National Infrastructure Planning  
Temple Quay House  
2 The Square  
Bristol, BS1 6PN

Our Ref: EN010127

### **Application by Mallard Pass Solar Farm Limited for an Order Granting Development Consent for the Mallard Pass Solar Project**

#### **Advice following issue of decision to accept the application for examination**

No dimensions are to be scaled from this drawing.  
All dimensions are to be checked on site.  
Area measurements for indicative purposes only.

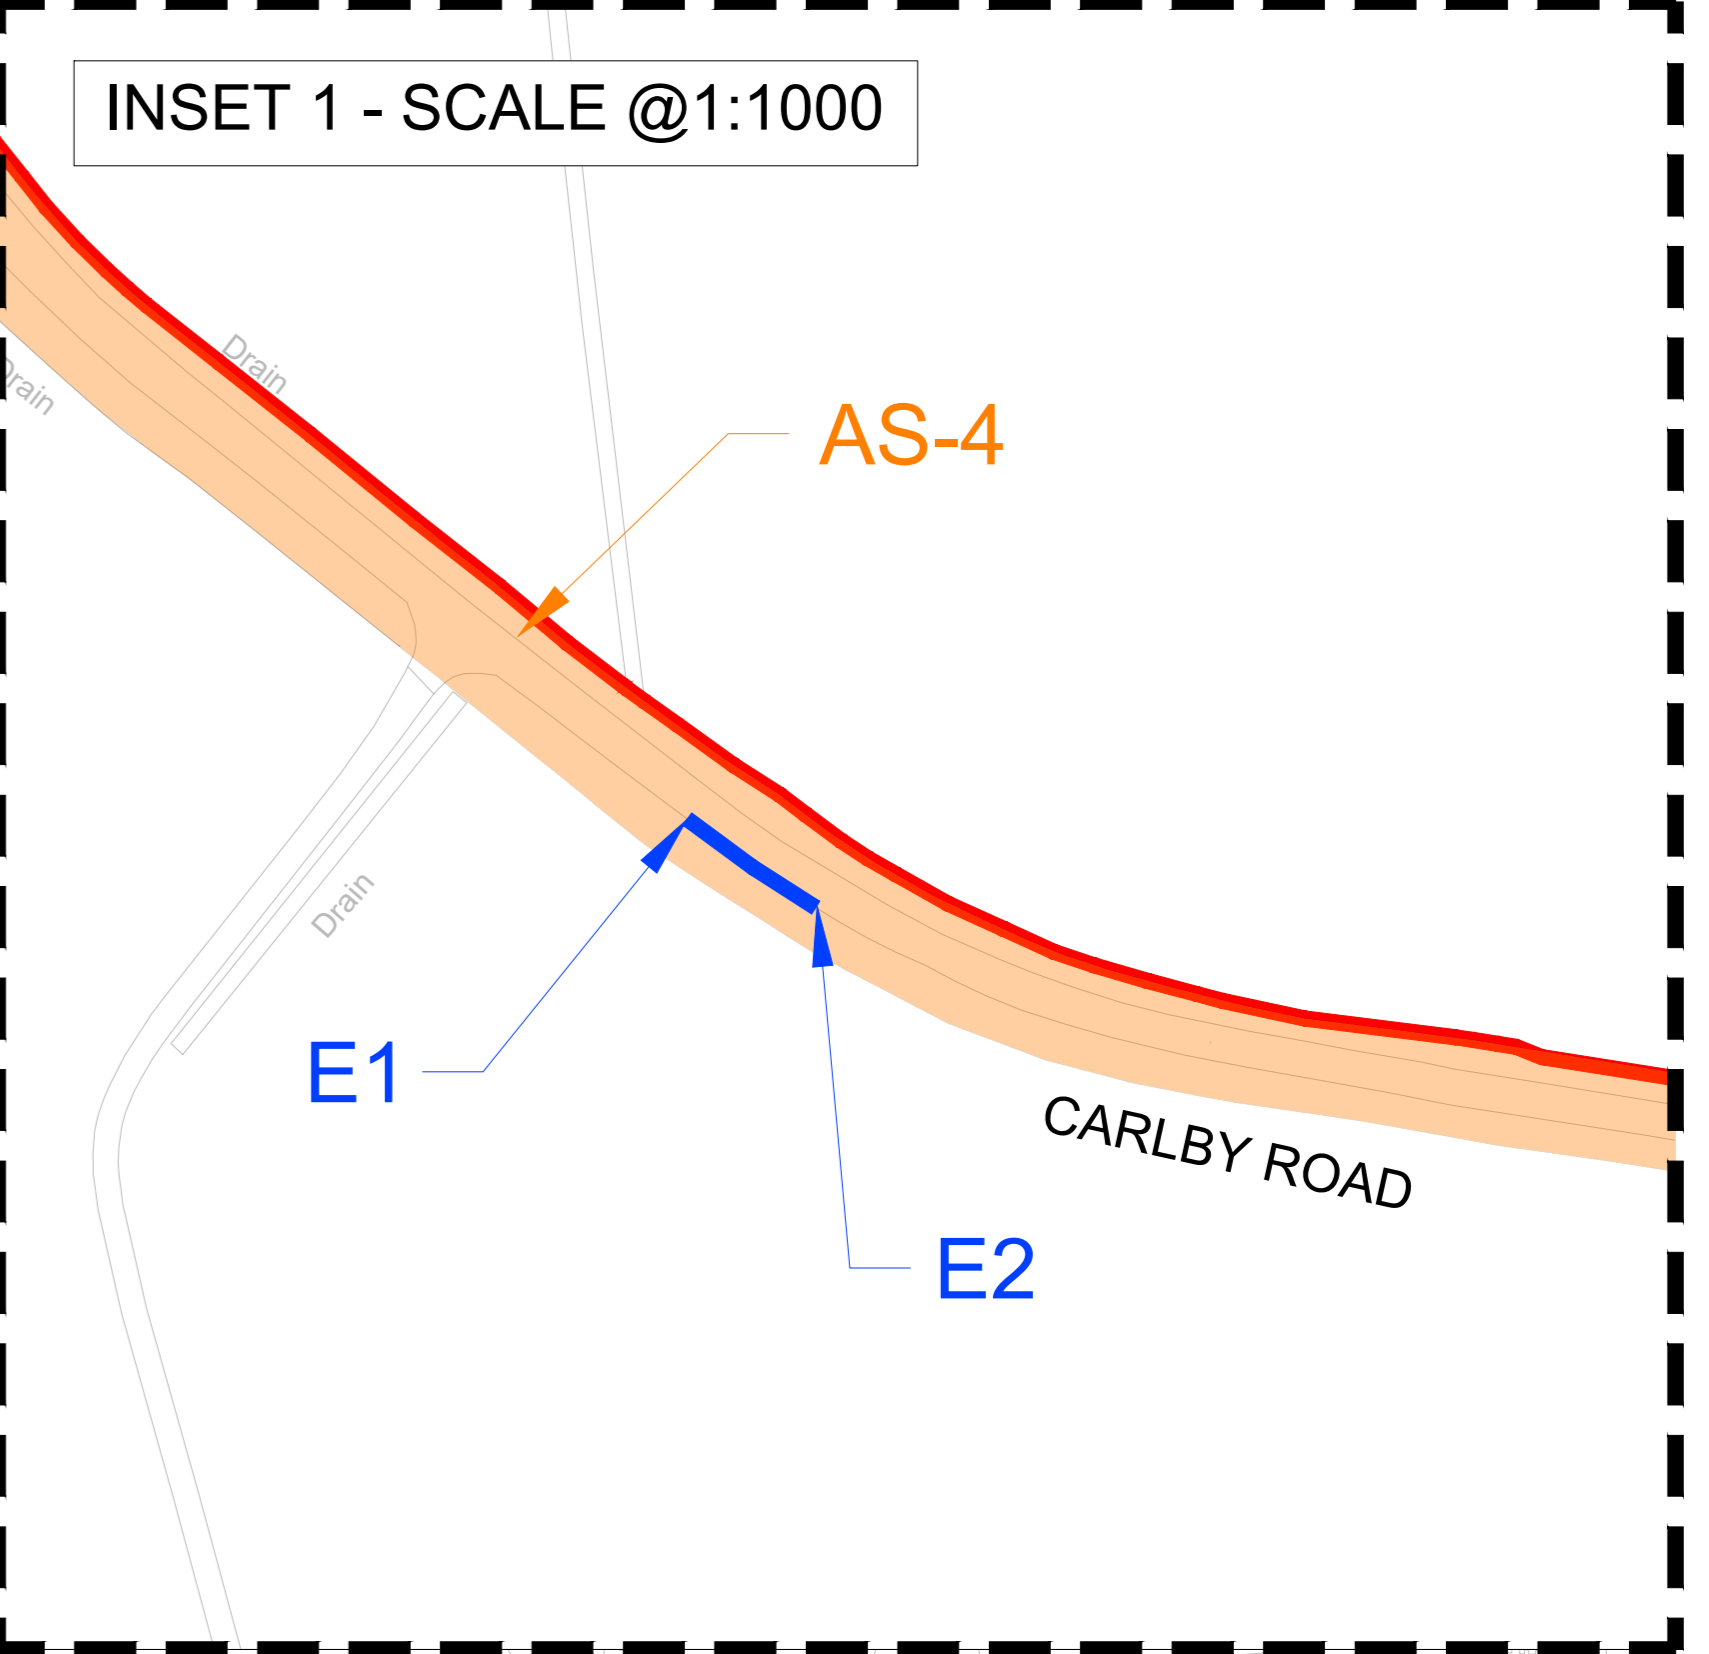
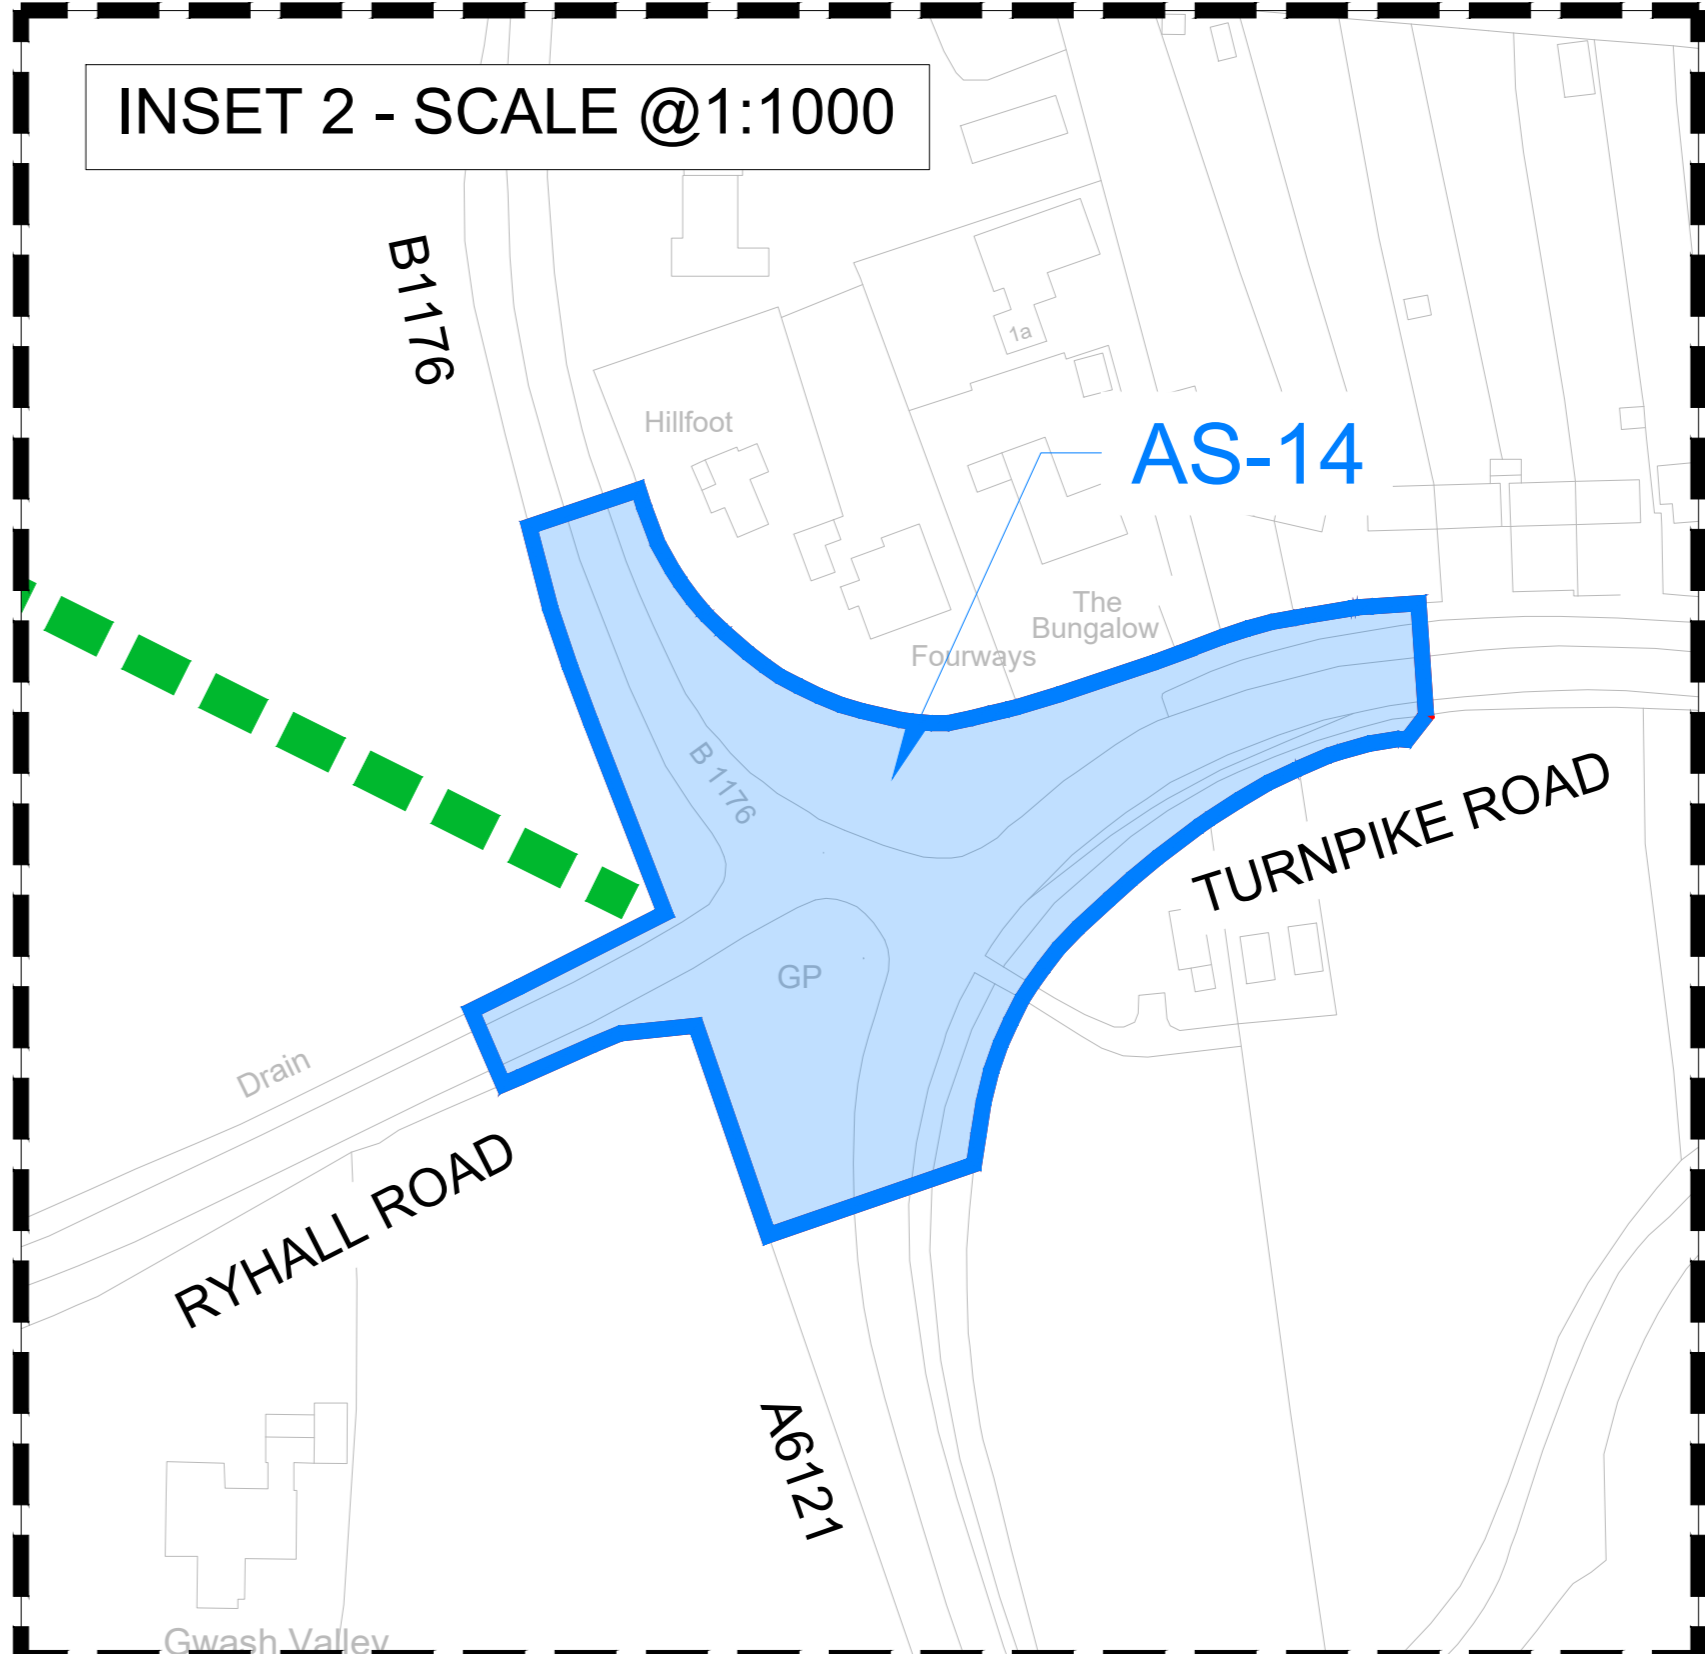
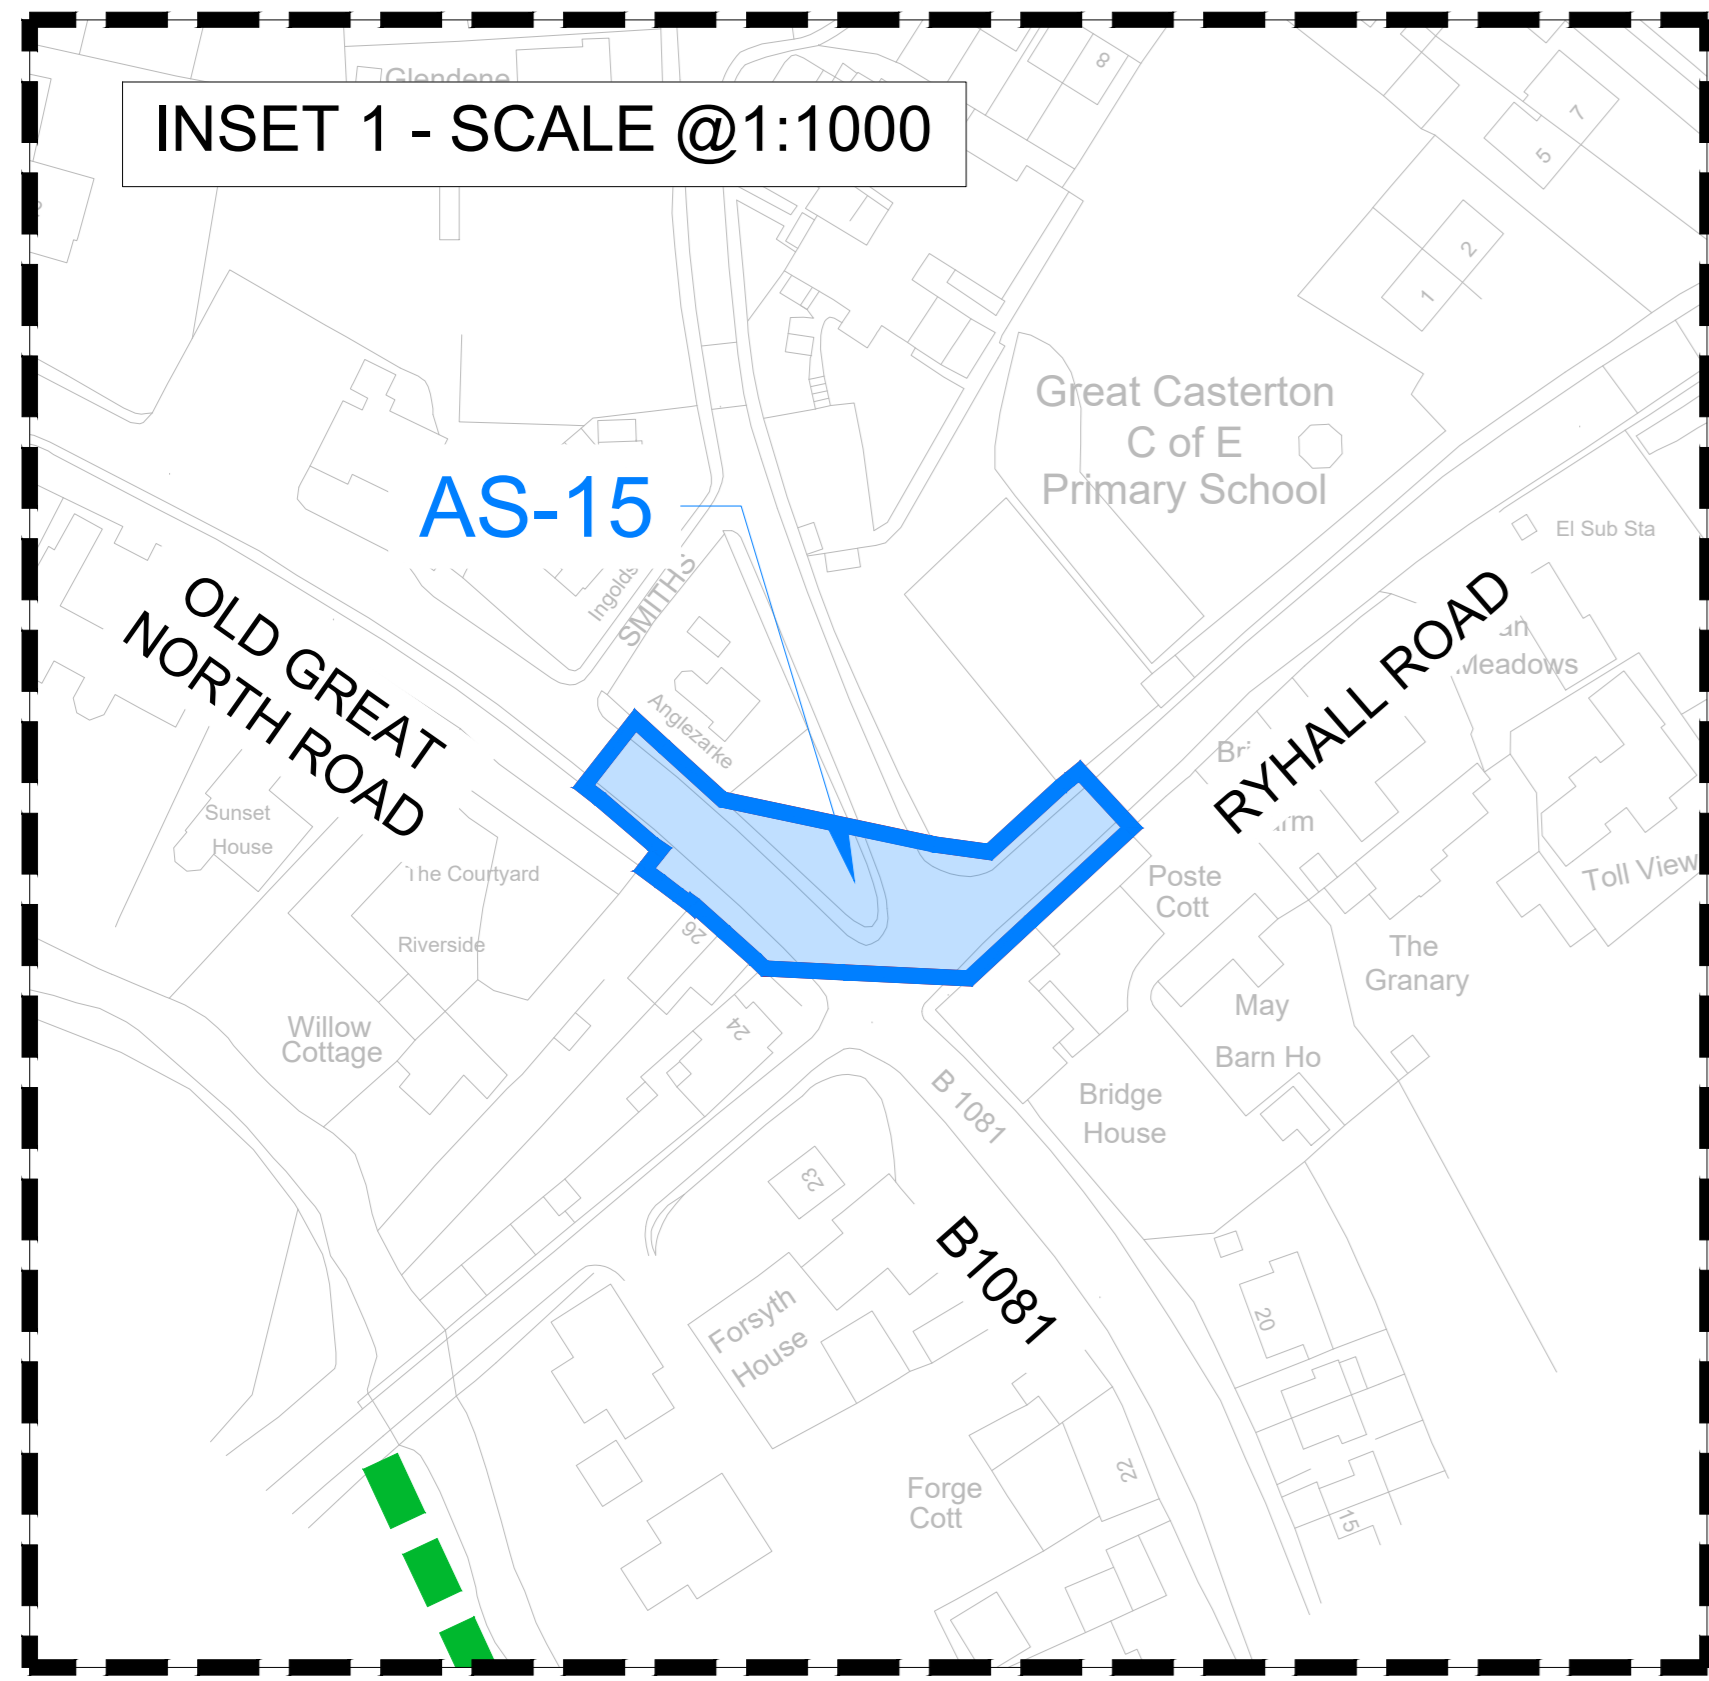
For clarity and to help understanding, existing public footpaths (public rights of way) should be marked and the plans more clearly notated to reflect the proposals, including differentiating works to footpaths and roads.
